Our Case Number: ABP-318816-24

Re: 10 year planning permission for wind energy development consisting of 8 no. wind turbines and all associated works
located at Cush, Galros West, Boolinarig Big, Eglish, and Ballindown, Co. Offaly.
(www.cushwindfarmplanning.ie)

From: Landuse Planning <LandUsePlanning@tii.ie>
Sent: Friday 1 March 2024 14:26
To: Strategic Housing Unit
Cc: Landuse Planning
Subject: TII submission ABP-318816-24_Cush Wind Limited (TII ref. TII24-125821)
Attachments: TII24-125821_SID windFarm and underground cabling Cush Co. Offaly ABP ref. PA19.318816_issued 01.03.2024.pdf

RE.: Wind Farm and underground cabling at townlands including Cush, Co. Offaly.

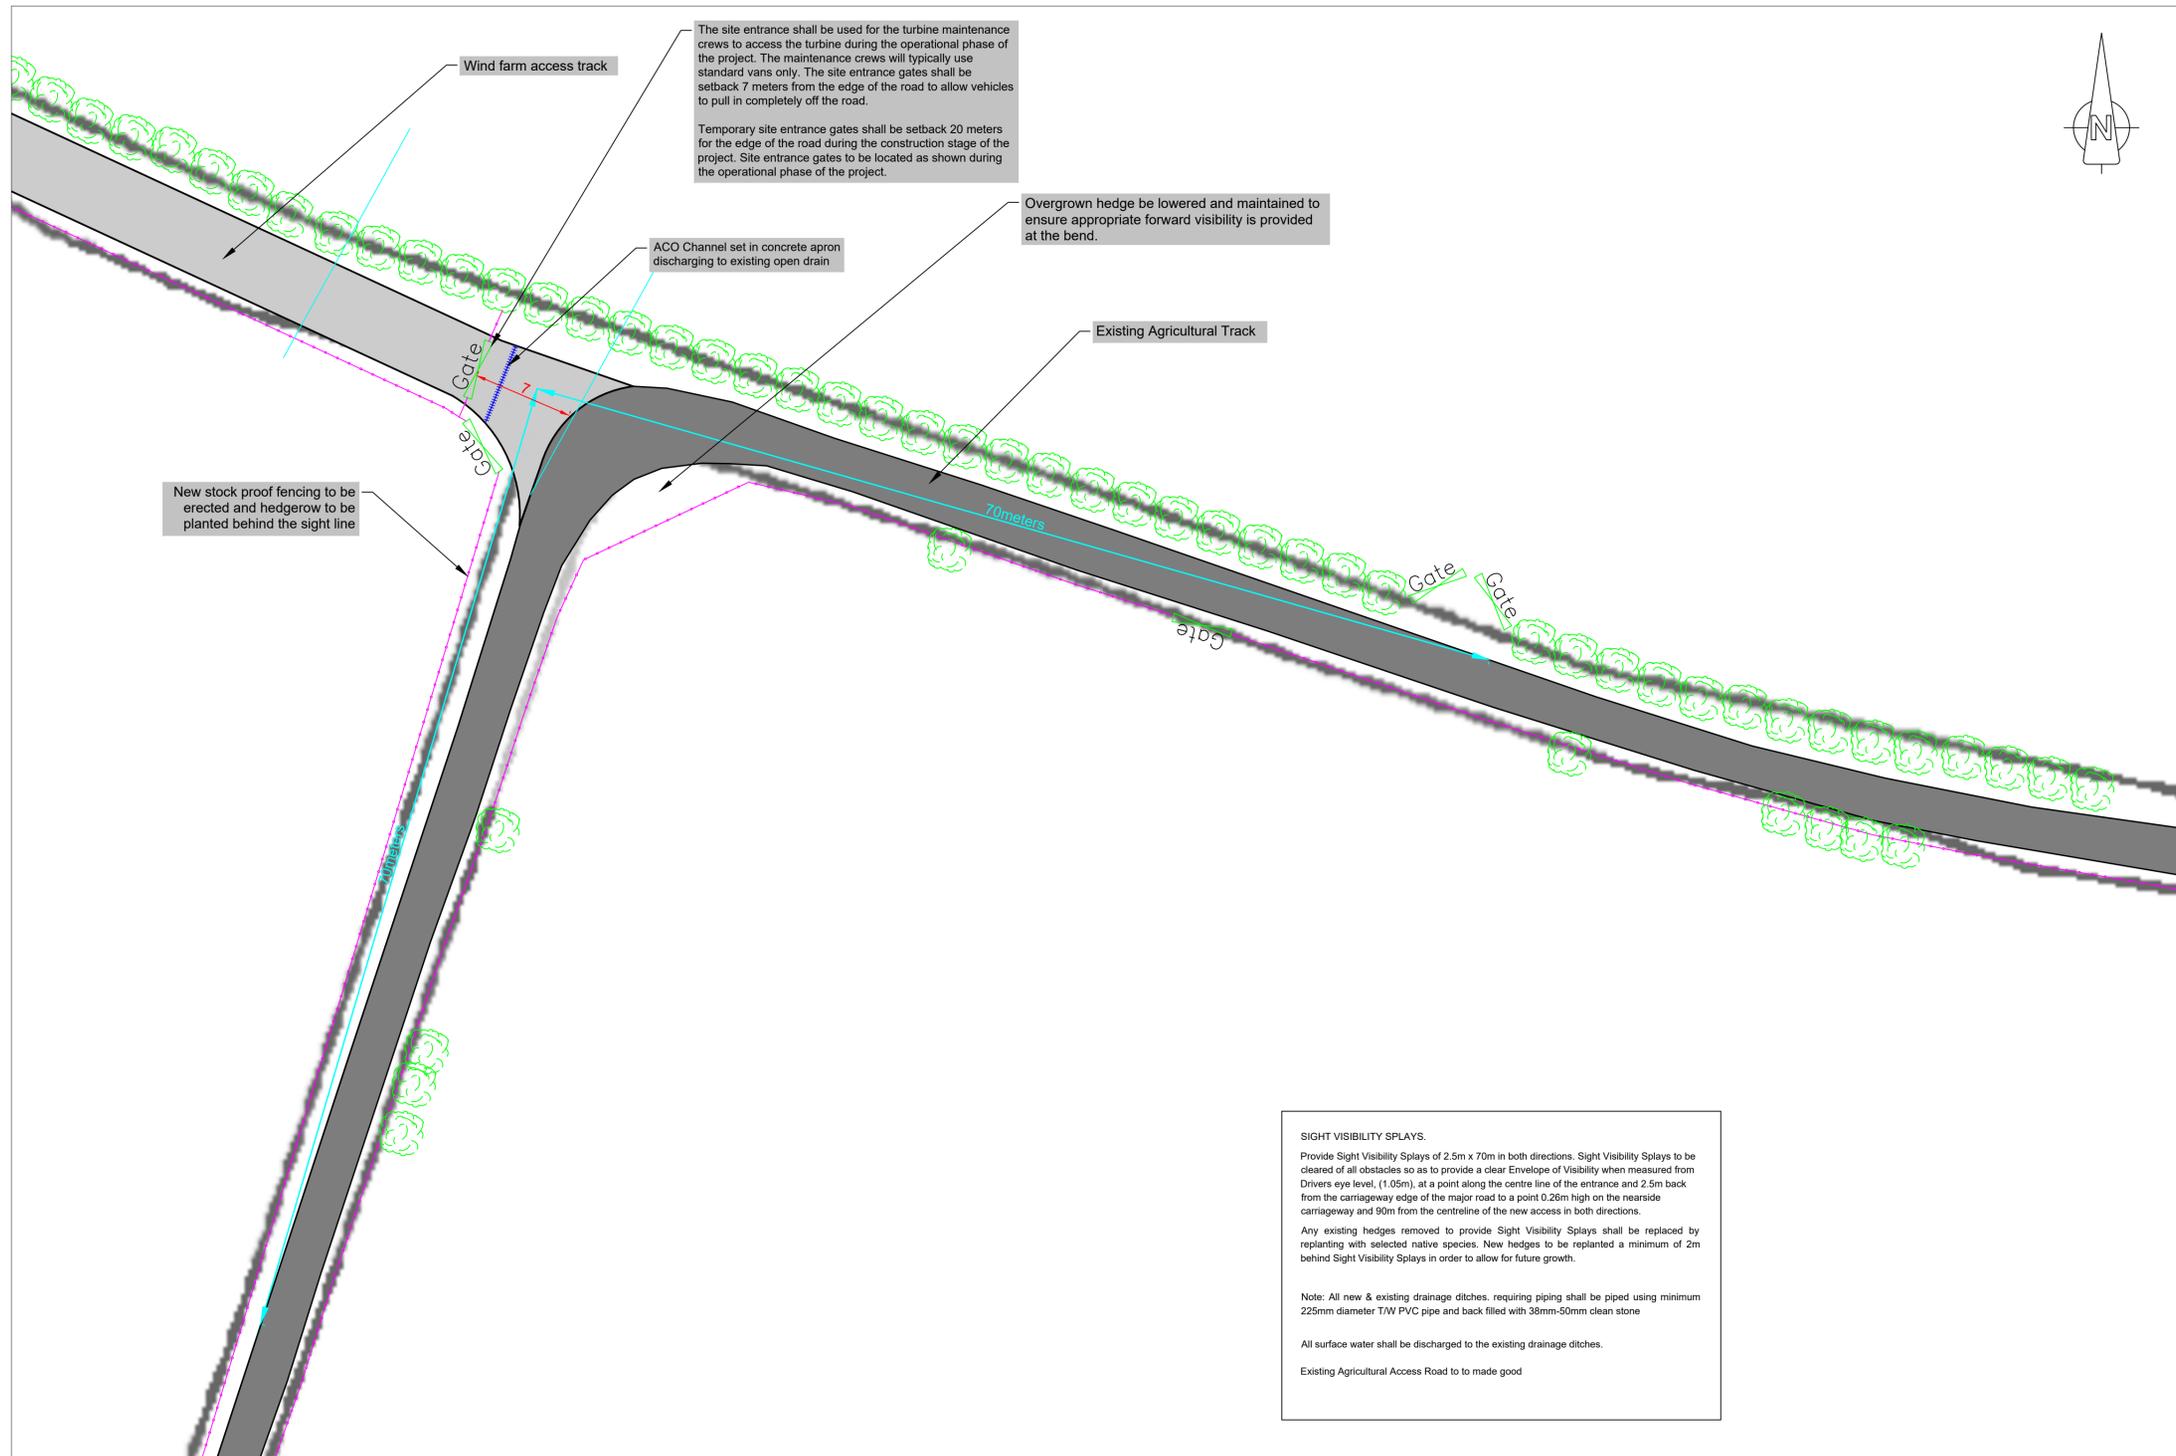
Lands to the immediate east of the junction of the N52 / N62 are included in the application boundary. As noted above, EIAR *Chapter 3: Description of the Project*, section 3.5 *Off-Site & Secondary Development*, includes subsection 3.5.1.3 *N52/N62 Junction to Wind Farm Site*. Submitted *Figure 4.7: Site Layout Map 7*, Dwg. No. CUS_PAS_LAY_007 indicates the installation of a “temporary turning head” at the junction of the N52 / N62.

Having regard to the EIAR description of this part of the development, it is understood that this turning head is to allow for “reversing the abnormal load from the N62 onto private lands, controlled by the Developer, before making a forward movement along the N62 towards the construction phase site entrances.” Accommodation works including removal of planting and road signage is stated necessary with commitment for full reinstatement after turbine component delivery. No entrance exists at the location indicated for this temporary turning head.

Chapter 13 *Material Assets* of the submitted EIAR includes Annex 13.1 *Stage 1 Road Safety Audit*. Having regard to the content of this Stage 1 Road Safety Audit, it is not apparent to TII that full regard to the “recommendation” 2.1 “Appropriate traffic management should be deployed to provide short ‘All Stop’ at an appropriate location on the N52 & N62 National Road mainline approaches” has been included in the proposed development either by reference to submitted drawings or EIAR text at EIAR *Chapter 3, Chapter 13, or Annex 1.9*.

- The proposed works for the proposed temporary turning head at the N52/N62 for the construction period has identified and had regard to TII Publications compliance requirements.
- The recommendation in the submitted Road Safety Audit is reflected in mitigation measures part of the proposed development. Therefore, proposed mitigation for the temporary turning head off the N52/N62 junction does not demonstrate adequate maintenance of the safe and efficient operation of the national road network has not been provided.

TII recommends that these matters are addressed prior to a decision being made on this application.

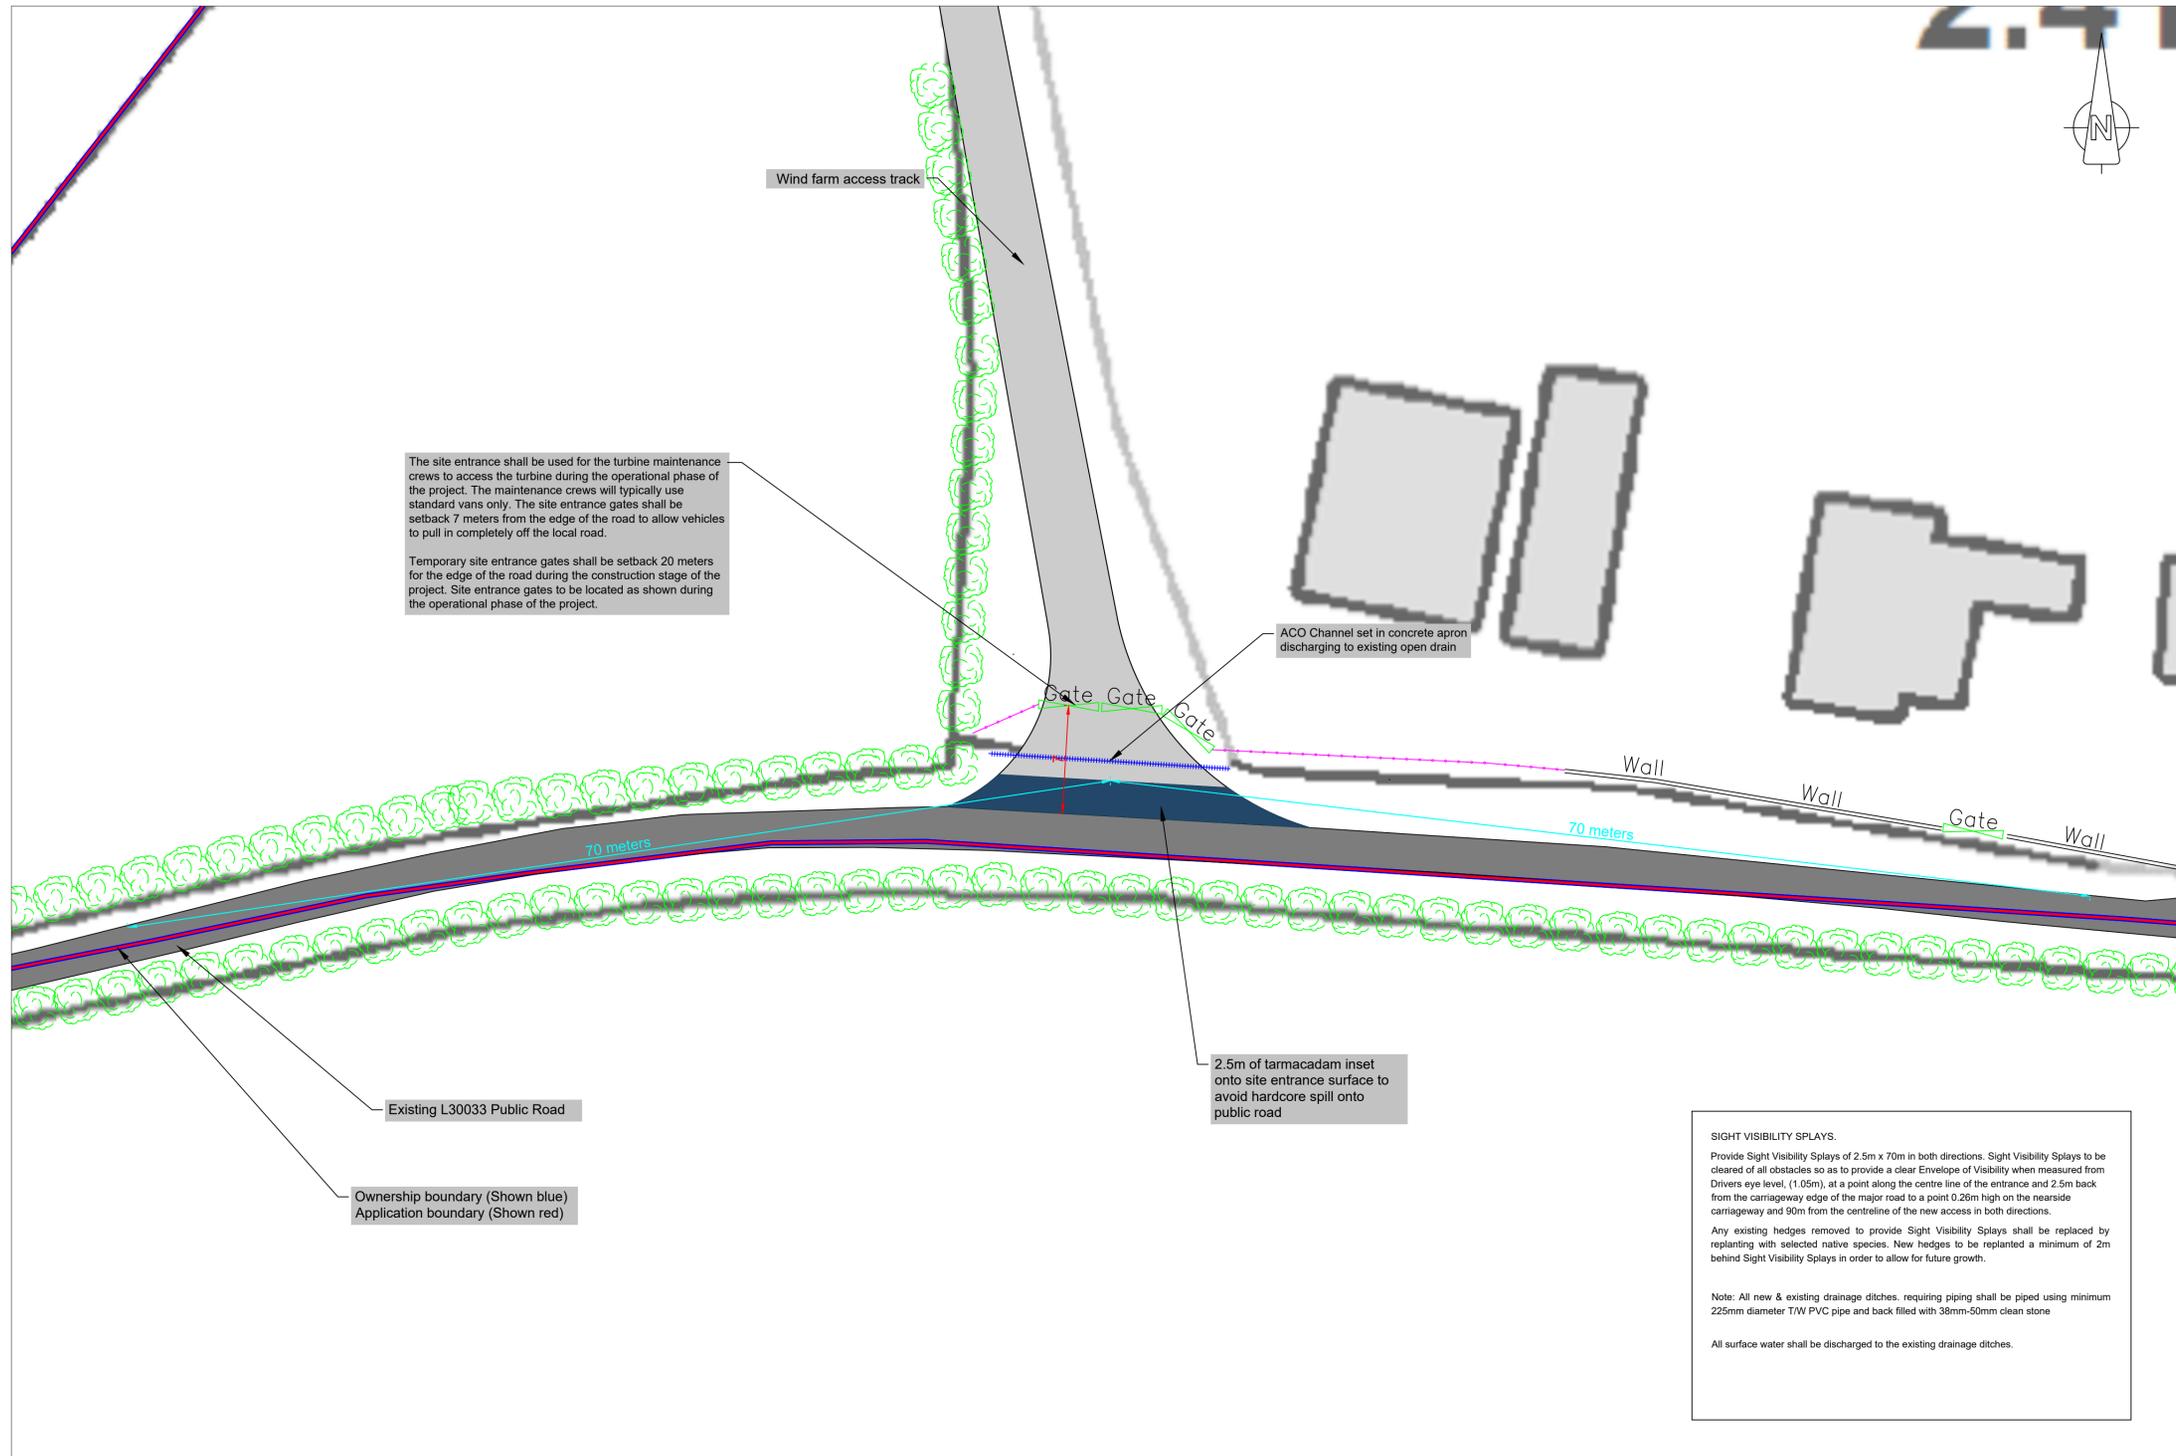
Drawing *Figure 5 - Temporary Construction Site Entrance Details*, Dwg. No. C US_PAS_GA_001, REV00 indicates works to install two opposing construction entrances, enlarged to accommodate “access for the oversize turbine components only. Area shall not be used for normal construction traffic.” The western entrance includes a “farm access” gate within the construction access entrance area. In view of the proximity of the main construction access to this indicated farm access, no rationale for this separate farm access appears provided in *Chapter 3* (subsections 3.4.5 and 3.6.2) or *Chapter 13*, (subsection 13.2.3.1) of the submitted EIAR.

Also indicated is an extended “tarmacadam” inset at each entrance “to avoid hardcore spill onto public road”, and setback roadside boundaries with new stock proof fence and hedge line to provide for sightlines (noted in *footnote 5* of submitted EIAR *Chapter 3: Description of the Project* “to provide sightlines in accordance with TII Publication Geometric Design of Junctions (priority junctions, direct accesses, roundabouts, grade separated and compact grade separated junctions) – DN-GEO-03060.”)

Having regard to the content of this *Stage 1 Road Safety Audit*, it is not apparent to TII that full regard to “recommendations” 2.3 and 2.4 that “An appropriate dwell area should be provided on the construction access track approach to the mainline” or “A suitable wheel washing facility should be provided to serve each of the construction site entrances” respectively, have been included in the proposed development either by reference to submitted drawings or EIAR text at EIAR *Chapter 3*, or *Chapter 13*.

Having regard to the EIAR assessment at *Chapter 13: Material Assets*, Annex 3.4 CEMP (Construction Environmental Management Plan) and mitigation measures as recorded in submitted Annex 1.9 of the EIAR, TII is not satisfied that the undertaking of works for the proposed temporary construction accesses or traffic management for the construction period in the vicinity of those proposed entrances, has identified and had regard to the status of the N62 as part of the national road network and therefore subject to TII Publications compliance. In TII’s opinion, proposed mitigation for the temporary construction accesses sufficient to satisfy the maintenance of the safe and efficient operation of the national road network has not been provided. This is a serious concern.

These statements (at subsection 3.4.5 and 3.6.2 of the submitted EIAR) appear inconsistent in that they appear to seek to retain access directly from the N62 during the operational phase of development despite stating elsewhere that the entrances will be completely removed and fenced off.

The proposed development includes installation of operational phase site accesses off local roads either side of the N62. TII consider that having regard to official national roads policy and public safety, a clear commitment is required to the temporary construction entrances being completely removed from this section of the N62 where the 100kph speed limit applies and appropriate provision for development requirements during operational phase to be via the local road accesses.
